Householder Proforma

Application Ref: 2021/1278
Address: 4 Wingfield Road, Athersley South, Barnsley. S71 3PS
Neighbour Representations: No
Property Description: the red brick semi detached property is located in a purely residential area of similar styled properties. It currently benefits from a flat roof projection which forms part of the original dwelling.

Proposed Extension: Erection of single storey rear extension to dwelling

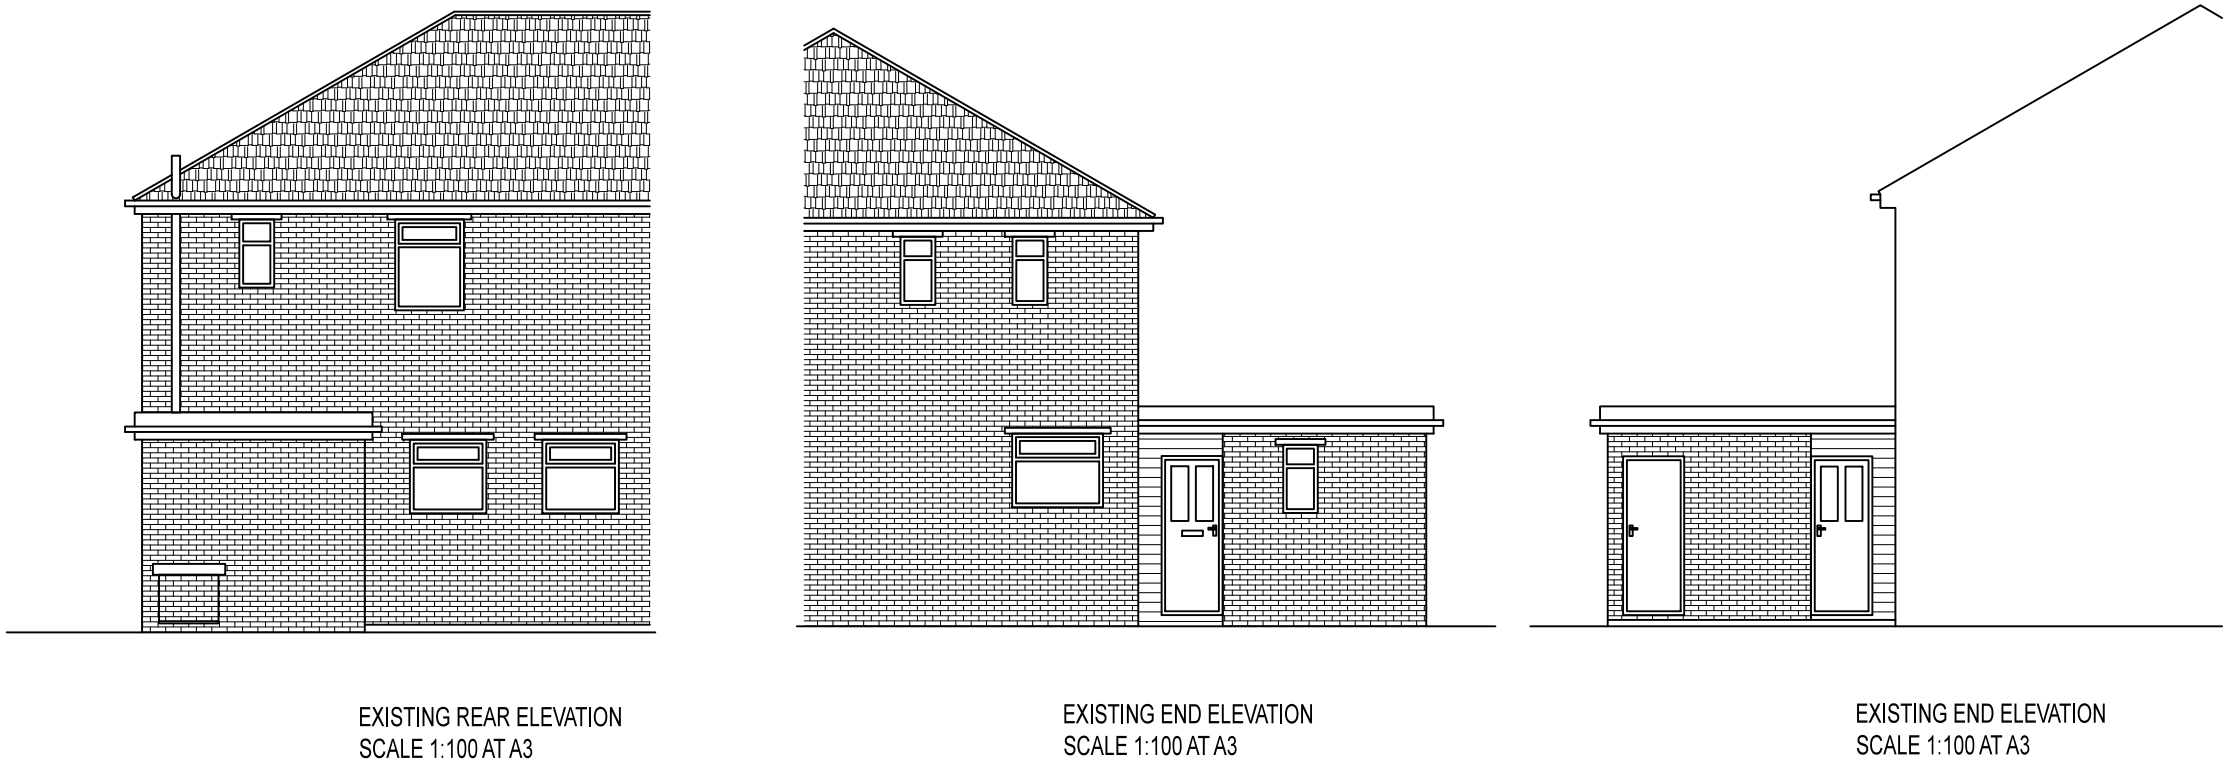
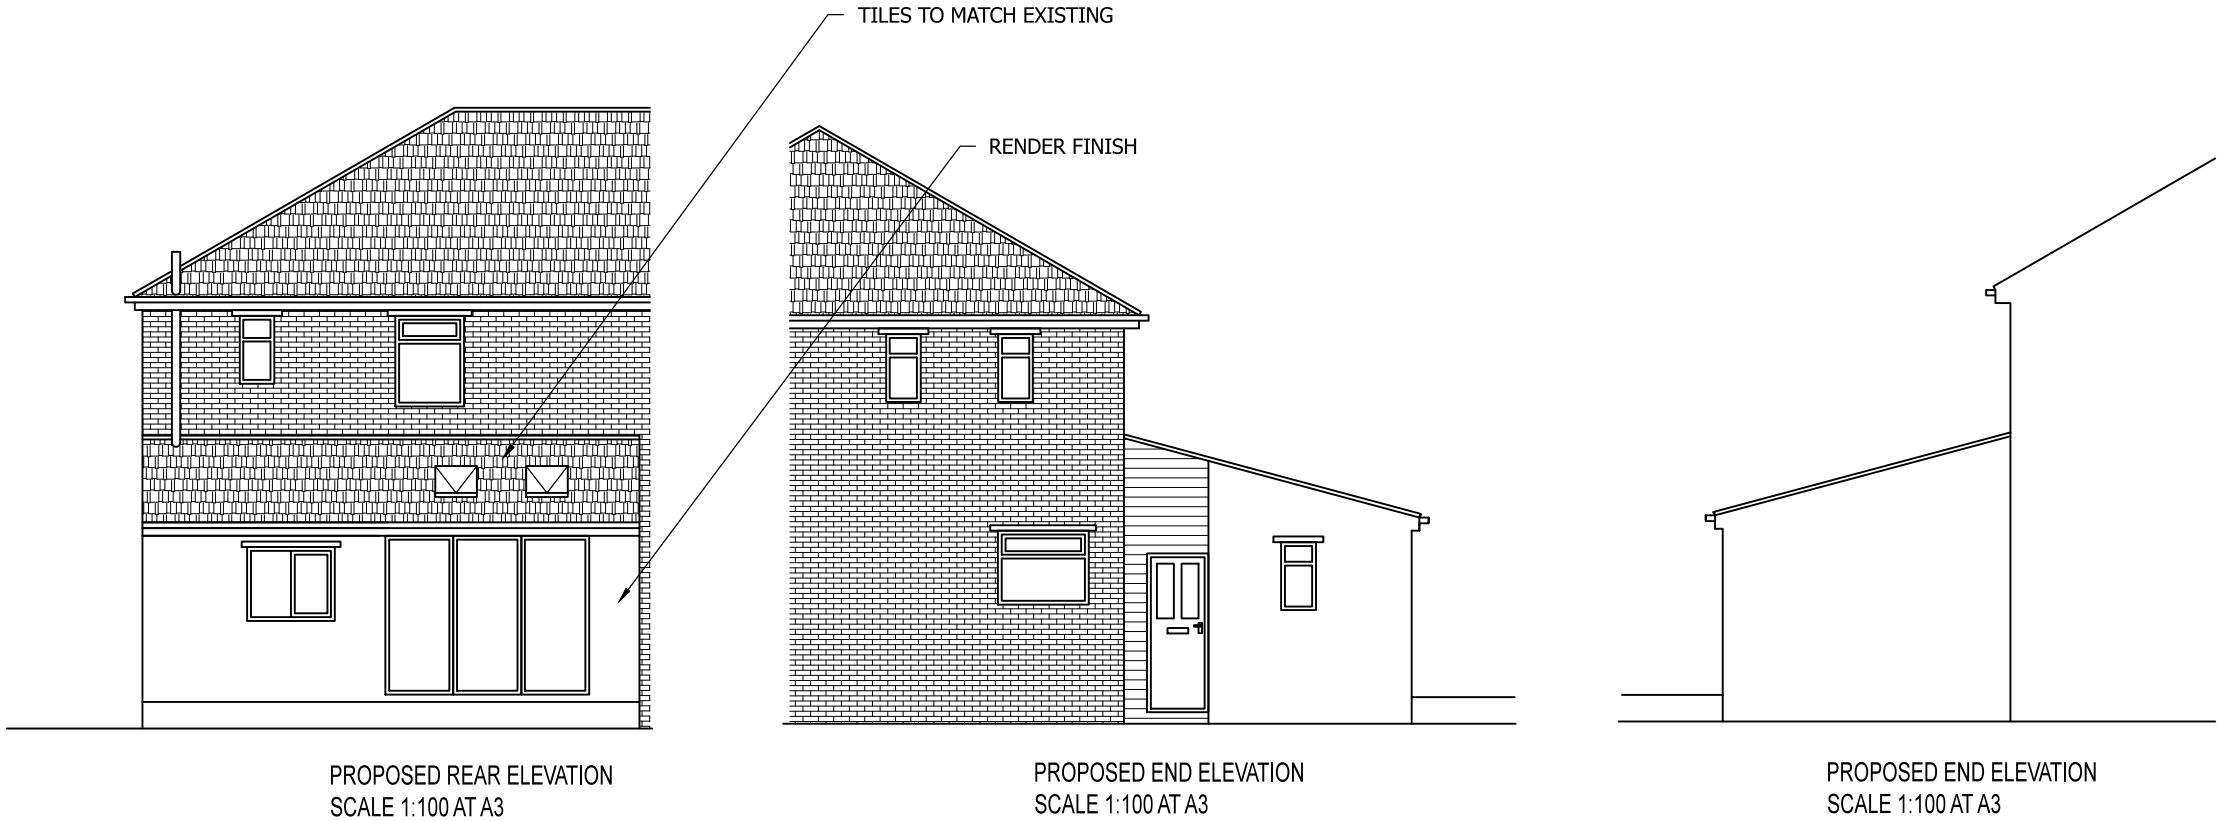
3. if more than 3m are the eaves more than 2.5m in height?	2.5m to the eaves 3.75m to the ridge
Two Storey	
4. terraced property and less than 2.5m (projection to the rear)?	
5. semi-detached and less than 3.5m?	
All	
6. materials to match	No; the applicant proposes to render the extension. It is considered given the extension is located on the rear elevation that the render would not pose a detrimental impact on the street scene and provides a contrast in materials between the old red brick of the dwelling and the new extension.
7. roof design compliments / ties in well	Yes
8. habitable room windows on the side elevation?	Small WC window on side elevation
9. distance to rear boundary (shared with another residential property) 10m or more?	Single storey extension with the boundary treatment providing adequate screening however 10m+ to rear boundary

Drawing Title
PROPOSED PLANS

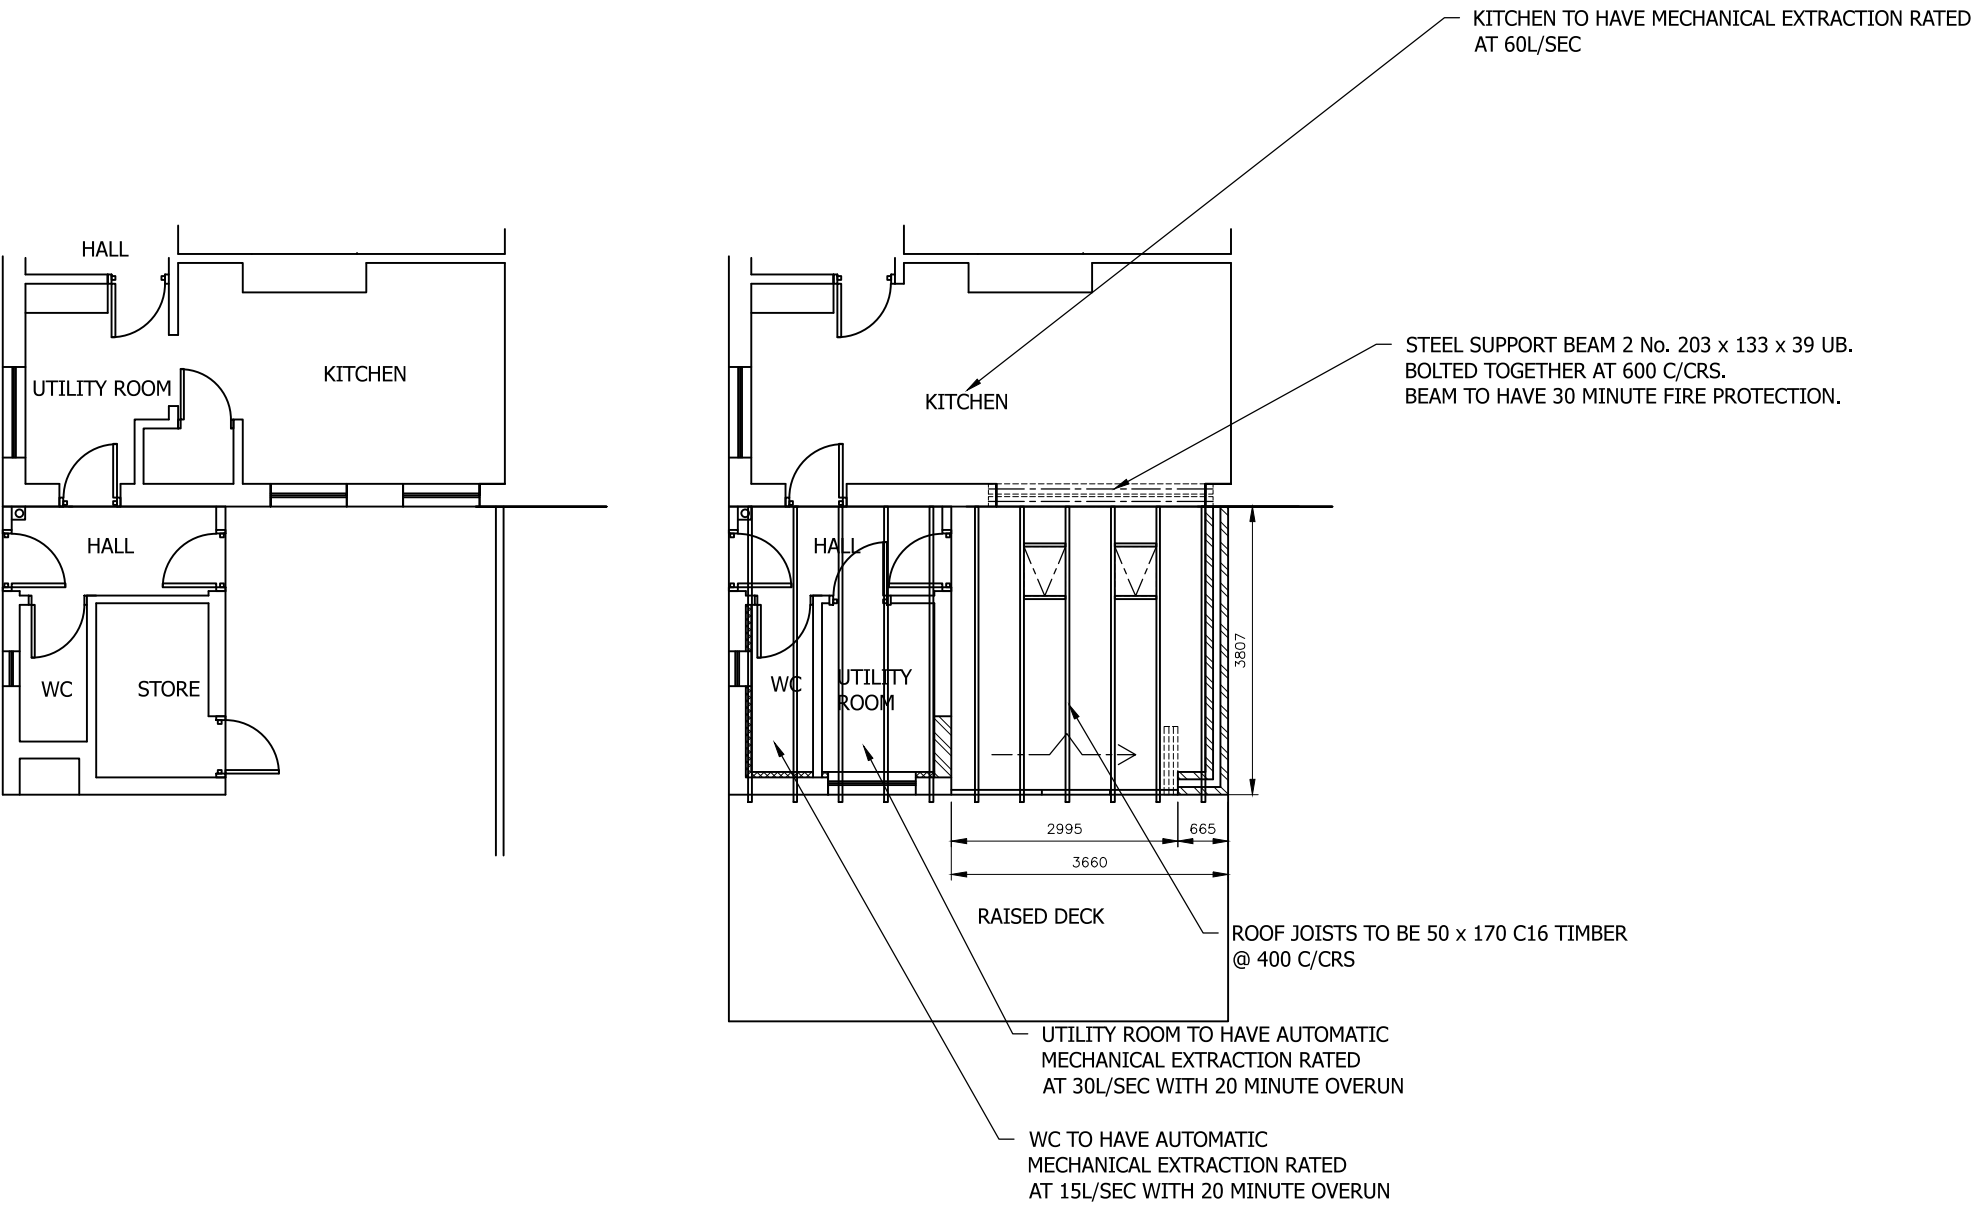
Yes / No (include comment if required)
Single Storey	
1. terraced property and less than 3.5m (projection to rear)?	
2. semi-detached and less than 4m?	3.8m

The plans also indicate a small raised platform/ patio area to the rear of the extension, the height does not exceed 0.3m and therefore does not require the benefit of planning permission as it falls within the parameters of PD.
